Case Number **EQ/21/50616**
Proposal **Proposed amendment to planning consent 20/00952**
Site **The Yews, Heath Lane, East Boldre, Brockenhurst, SO42**
 7WF

Your Reference: 21/50616

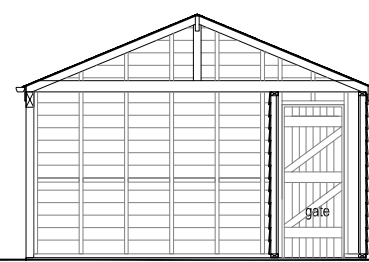
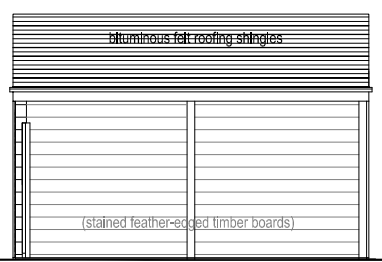
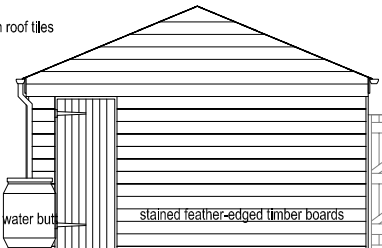
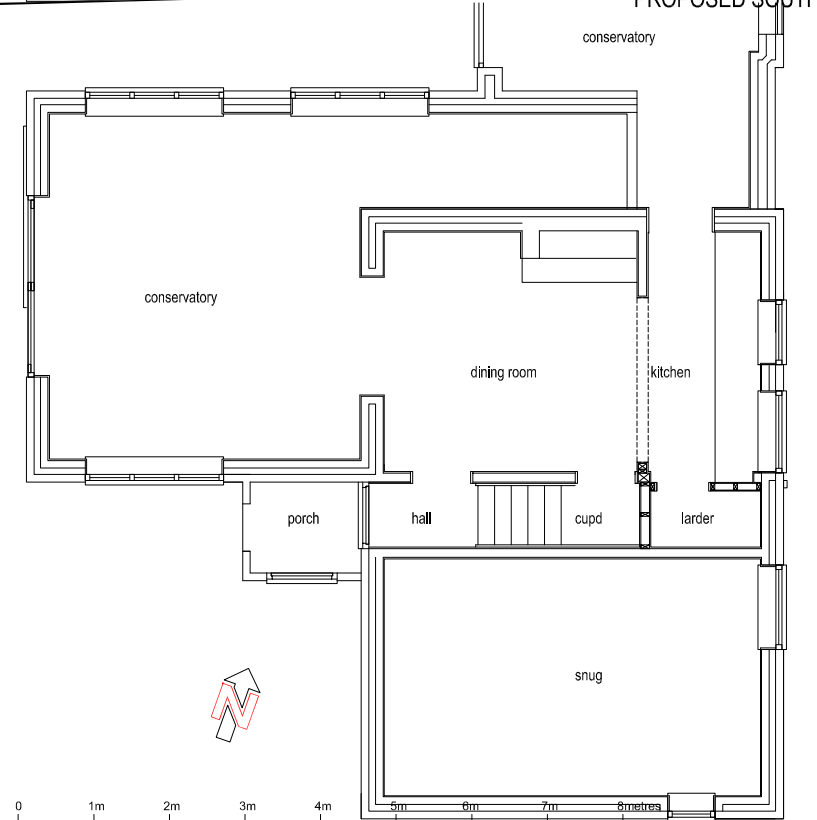
From the description of the proposed alterations to the outbuilding, it would be my opinion that the changes would result in a materially different outbuilding to that approved. I therefore disagree with the builder's agent, and planning permission is required. A Lawful Development Certificate would fail as the height would exceed the limitation of 2.5 metres within 2 metres of a boundary. As the previous permission was issued less than one year ago, it is likely that the changes could be applied for as the first revision (or 'free go') to 20/00952.

I would also note at this stage that a ridge height of 3.7-4 metres may not be considered appropriate. It may be beneficial to submit the proposed changes as a pre-application enquiry in order to ascertain whether permission would be forthcoming should an application be made.
